**QANTAS FLIGHT TRAINING CENTRE - STATE SIGNIFICANT DEVELOPMENT (SSD 10154)
SUBMISSION – CORPORATE CONNECT**

This submission has been prepared by AMP Capital in response to the exhibition of the Qantas Flight Training Centre State Significant Development Application (SSD 10154). As the owner of Corporate Connect at 185 – 191 O’Riordan Street, Mascot, AMP Capital would like to thank the Department of Planning, Infrastructure and Environment (the Department) for the opportunity to review and provide comment on the application.

Figure 17 Proposed Multi Level Carpark Eastern Elevation

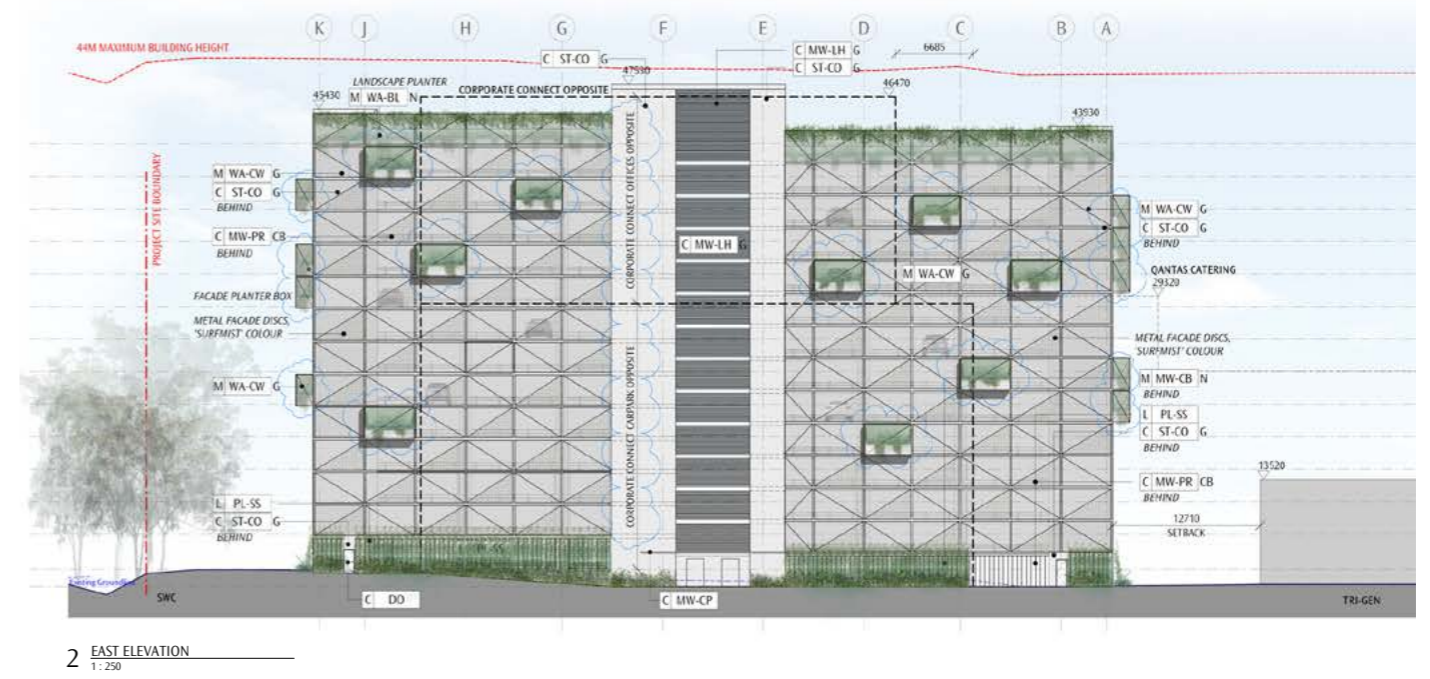
The new car park will present a new and dominant interface to the western façade of Corporate Connect, largely replacing the current uninterrupted district views over the airport with a multi-storey car park. Whilst AMP Capital has no issues with the proposed building or its height, AMP Capital are concerned that the current façade design does not go far enough to ameliorate the view impact of the new building on the shared interface. Currently, the design includes planting that climbs up from Ground, while vegetation is also proposed in a roof garden. Vegetation would have a limited ability to climb more than 1-2 storeys, leaving a significant amount of façade structure exposed. With this in mind and as the most affected landowner by the proposed car park we request the Department require the following:

- Additional planter boxes should be required to be integrated into the eastern façade in a staggered manner, allowing additional vegetation growth which will soften the building along this façade and ameliorate the impact of the new building;
- The applicant should provide detail on how the planting infrastructure will be integrated into the design and what measures will be used to ensure the health and survival of planting on a long-term basis;
- The Department should include a condition in the development approval requiring the maintenance of on-structure gardens.

Picture 4 – Signage at the eastern elevation of Stage 2 carpark

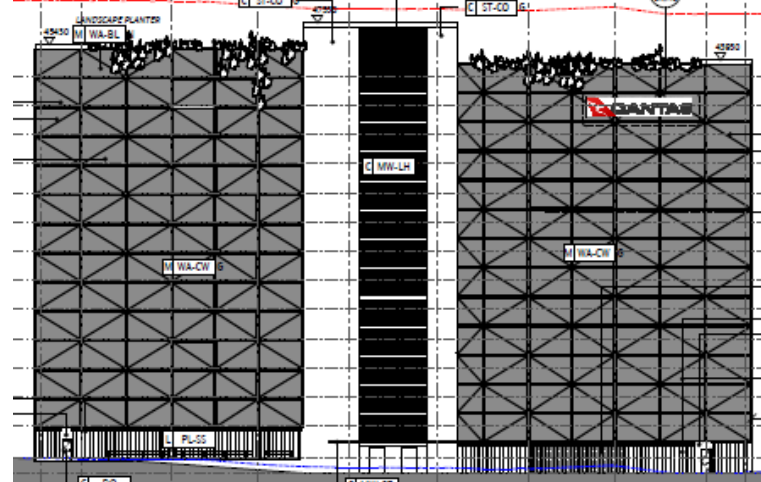
A building identification sign is proposed on the eastern facade of the car park that is 10.25m long and 2.03m high (**Figure 3**).

It is noted that many workers in Corporate Connect work beyond typical daytime hours and the alignment of the illuminated sign is expected to face directly into the upper levels of the Corporate Connect building, presenting workers with a potentially dominant and distracting view. We note that the SEPP 64 assessment indicates that the illuminated sign will have adjustable settings, however the sign regardless of illumination presents an issue for workers.

The location of the car park within the site means that the proposed sign at this location facing is internal, with no street frontage. The need for a sign on this particular facade is therefore questioned, due to the impact on the closest neighbour.

- Require the building identification sign to be relocated to the northern facade, where there is a much greater separation to potential receivers.
